Rezoning Transportation Analysis

Petition Number: 2023-068

Date	Description
8-24-23	First Review (JP)

RZ2.00

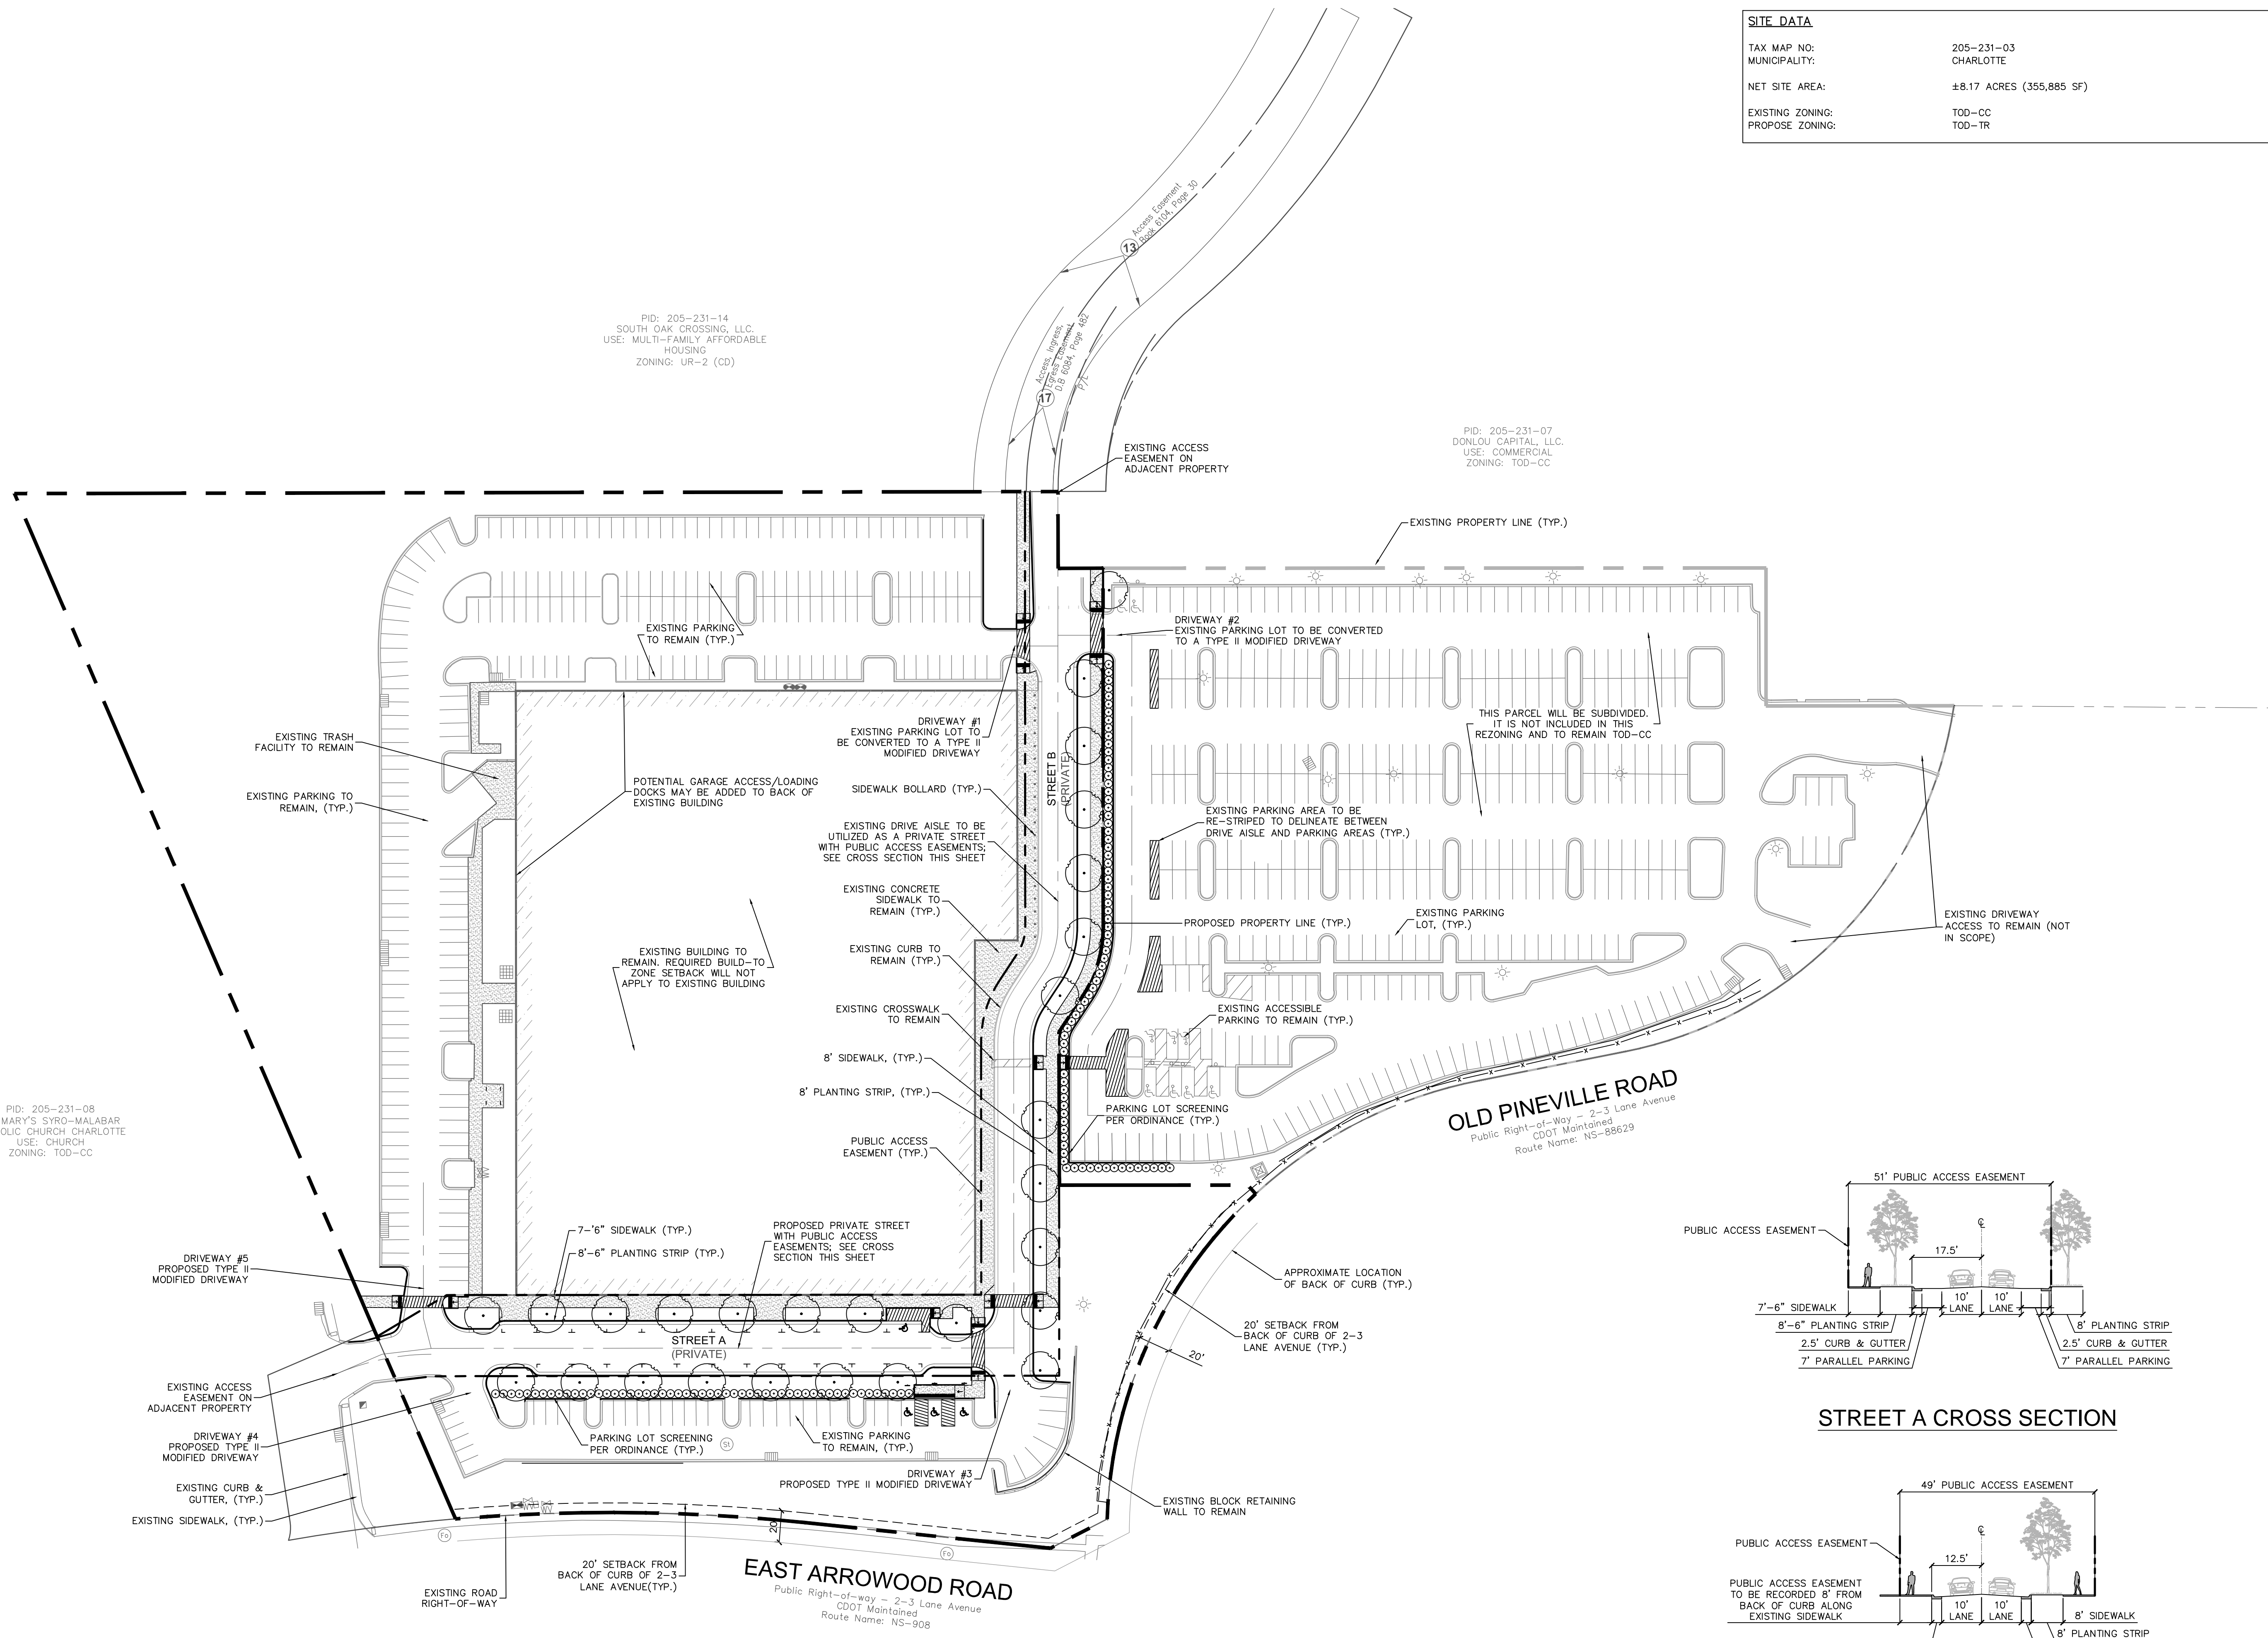
- a. **Arrowood Road:** Location of future curb and gutter to be moved to 27 feet from roadway centerline to the back of curb to accommodate the Charlotte Streets Map with a roadway typical section of a 2+ Avenue with buffered bike lanes.

- b. **Old Pineville Road:** The future location of curb and gutter is in its existing location.

Label and dimension the curb and gutter from the centerline for each road on the site plan.

4. Revise site plan to show the entire cross-section of Arrowood Road and Old Pineville Road along the site's frontage. Dimension the right-of-way, back of curb, and future back of curb from the centerline of each public street.

5. Revise site plan to clarify land use and density.
6. Revise site plan and conditional note(s) to commit to removing the southern driveway on Old Pineville Road.

7. Revise site plan and conditional note(s) to commit to fixing the erosion issues at the corner of the site at Old Pineville Road and Arrowood Road.
